Our ref: DOC21/407920  
Senders ref: SSD-10831778

**Subject:** Exhibition – Sydney Children's Hospital Stage 1 and Children's Comprehensive Cancer Centre (SSD-10831778)

## **Attachment 1: EES comments on Exhibition of Sydney Children's Hospital Stage 1 and Children's Comprehensive Cancer Centre (SSD-10831778)**

### **Floodplain Risk Management**

1 ELEVATION 03 - NORTH
1:200

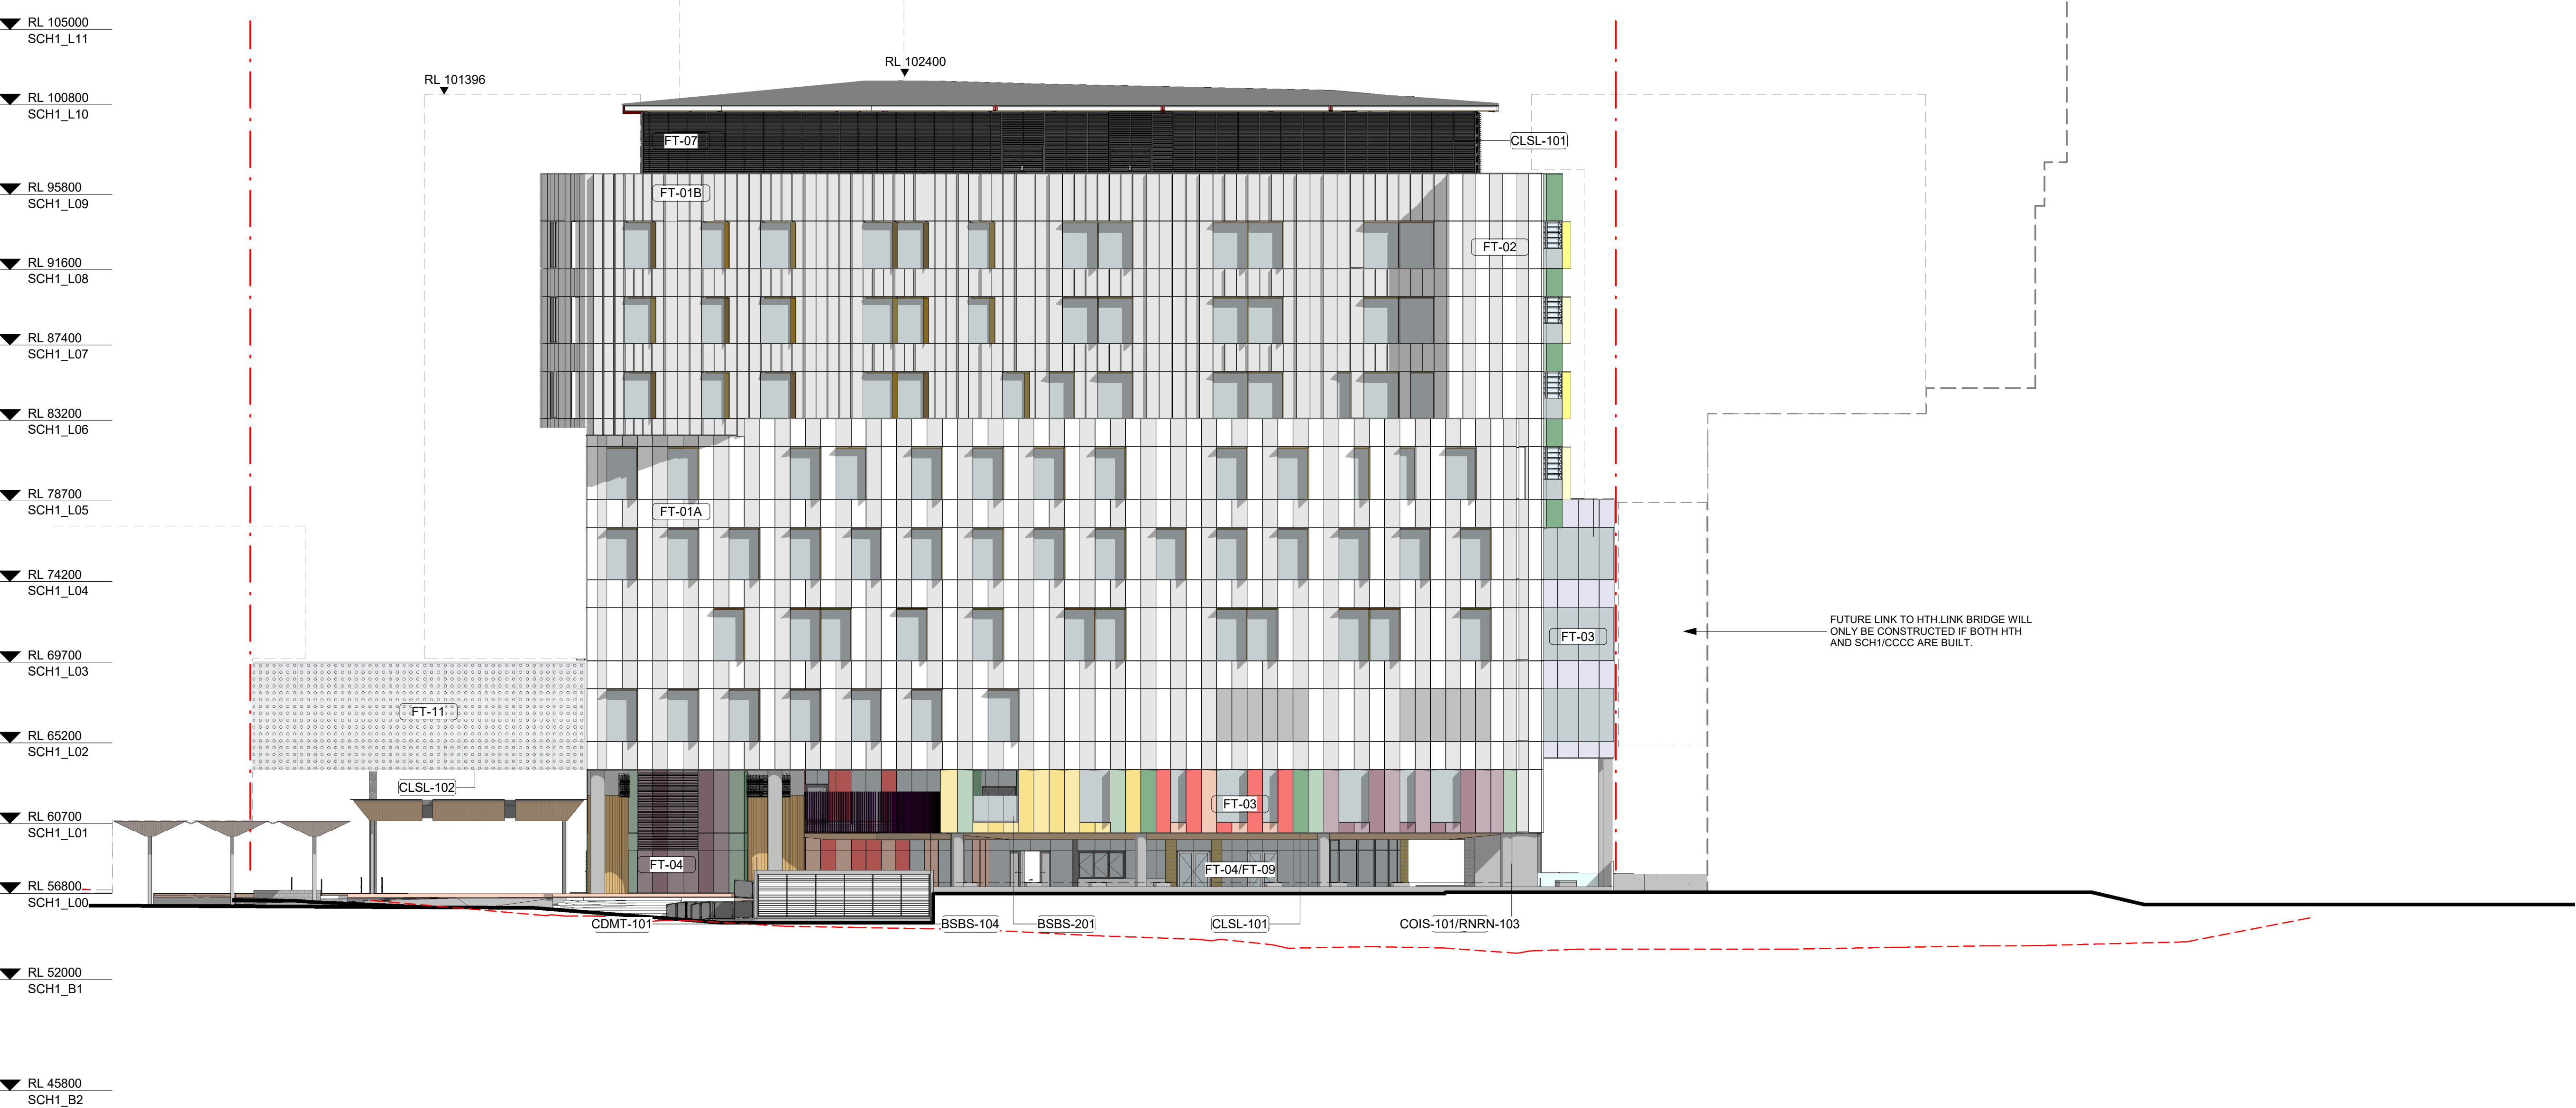
- Basement carparks (the PMF event or 1% AEP event plus 500 mm freeboard would apply)
  - The driveway from Botany Street, and
  - Air vents/louvre openings along the north elevation, including specification of the minimum permissible level(s) for any such openings on architectural drawings.
